RE: Pomeroy Critical Areas Variance
Your Letter Dated April 12, 2000
PCE Job No. POMY-0001

VAR0006-001
VAR0003-002
VAR0003-007

The following summarizes the applicant's responses to your letter referenced above. The numbering scheme used below follows your letter.

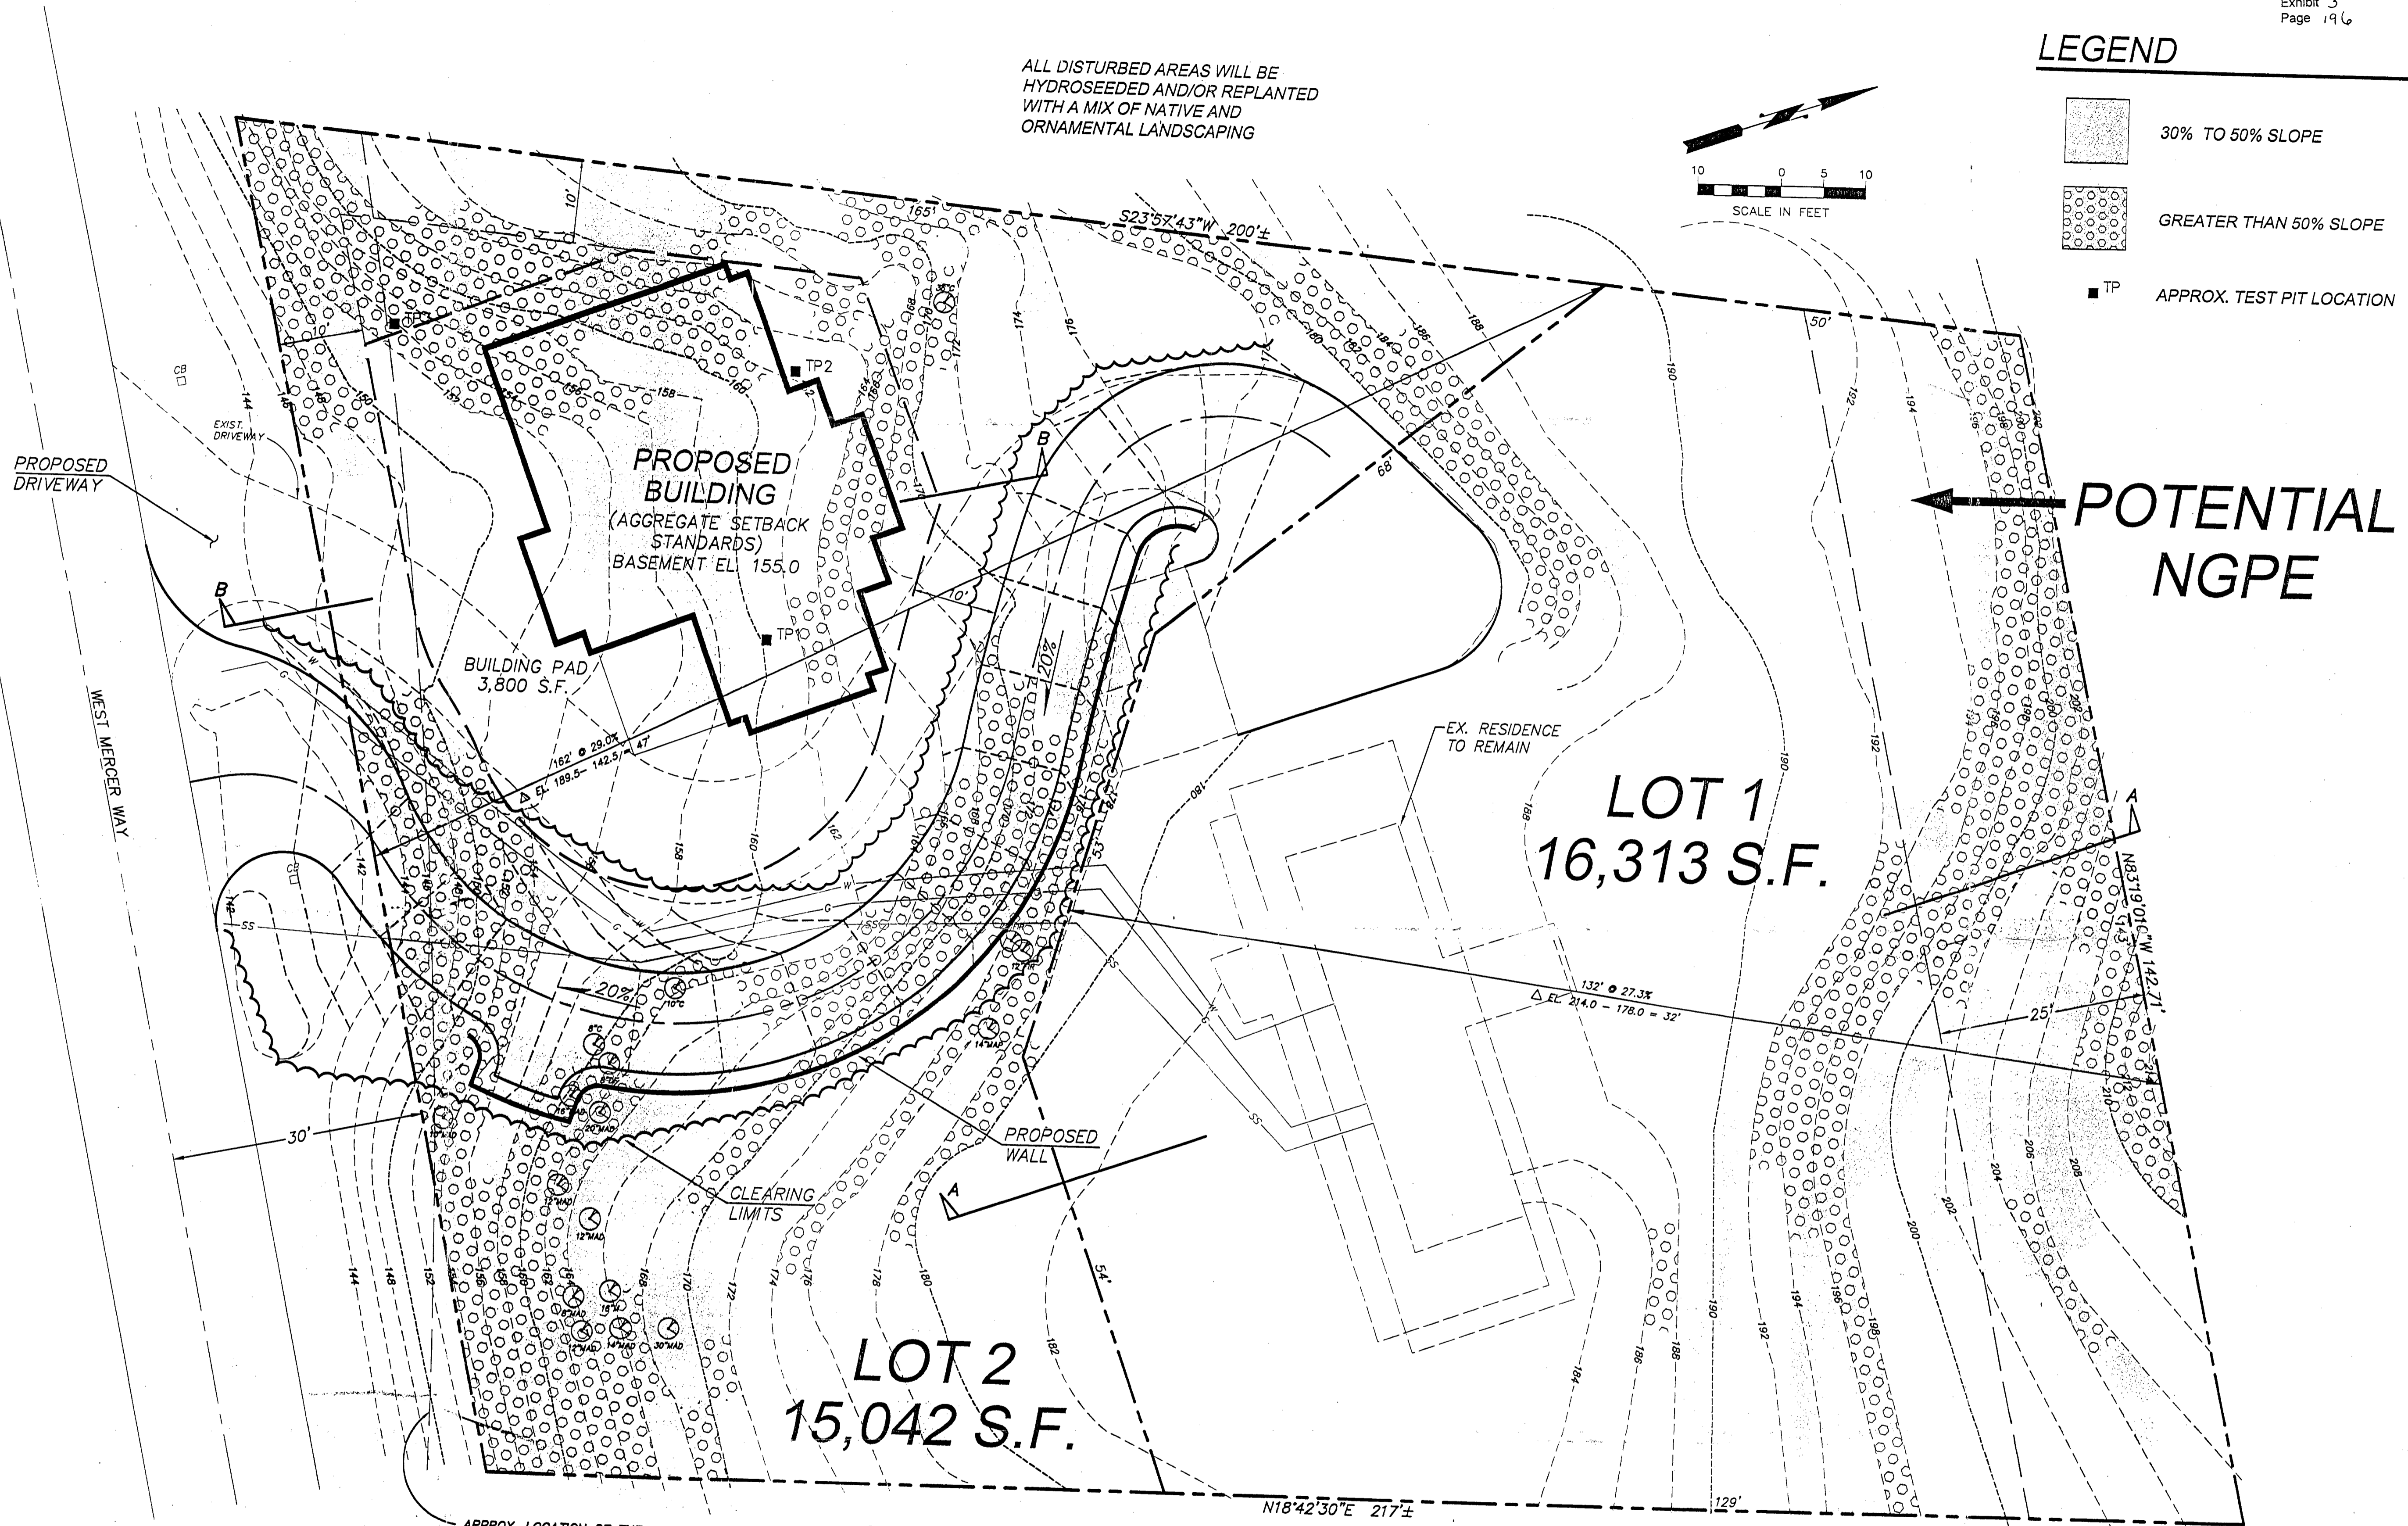
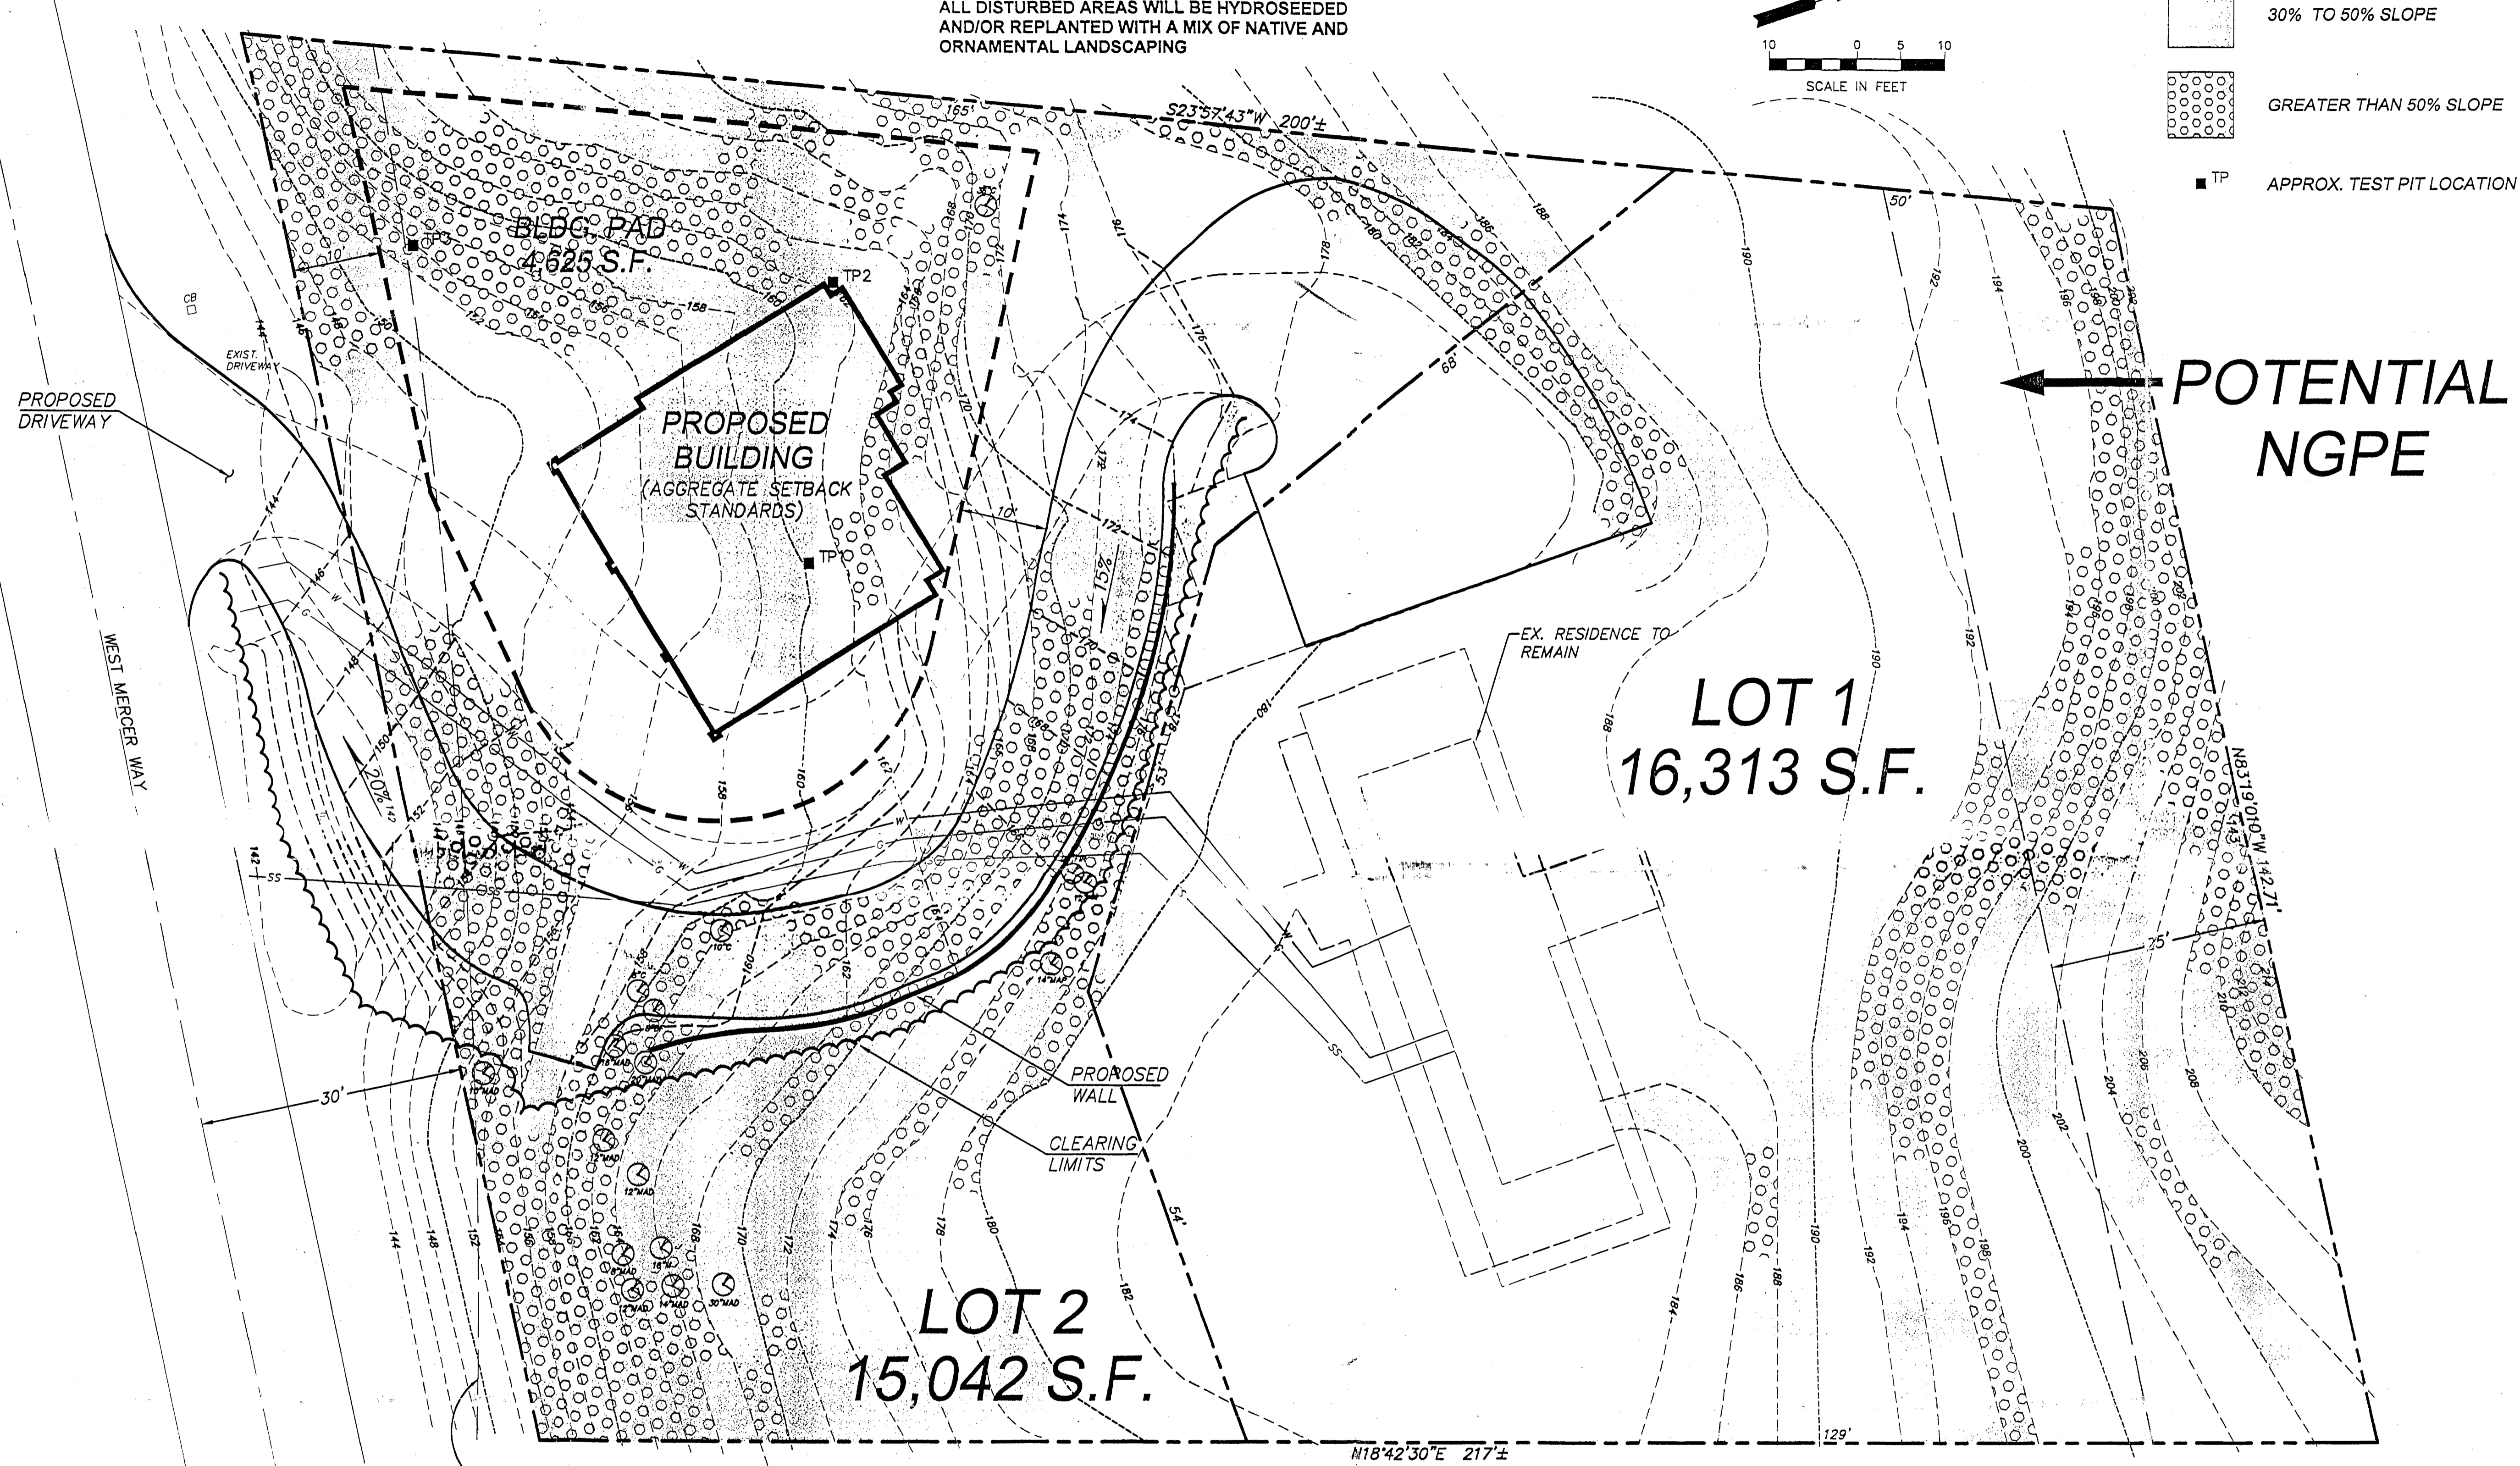
1. We anticipated an application for a lot size variance would be necessary; however, we did not intend to submit for the zoning variance until the outcome of the critical areas variance was determined in an effort to minimize Mr. Pomeroy's consultant expenses. An application for the lot size variance has now been submitted.
- 2 & 3. The lines that were used to compute the "lot slope" based on your methodology are shown on sheet 3 of 3.

The impervious area allowed using your methodology is more permissive than we used on sheet 3 of 3. We presume the figures shown above will control.

8. The building pad has been reduced to 3,800 square feet (see sheet 3 of 3) and in the applicant's opinion, is the smallest pad that will allow the construction of the proposed home and driveway.
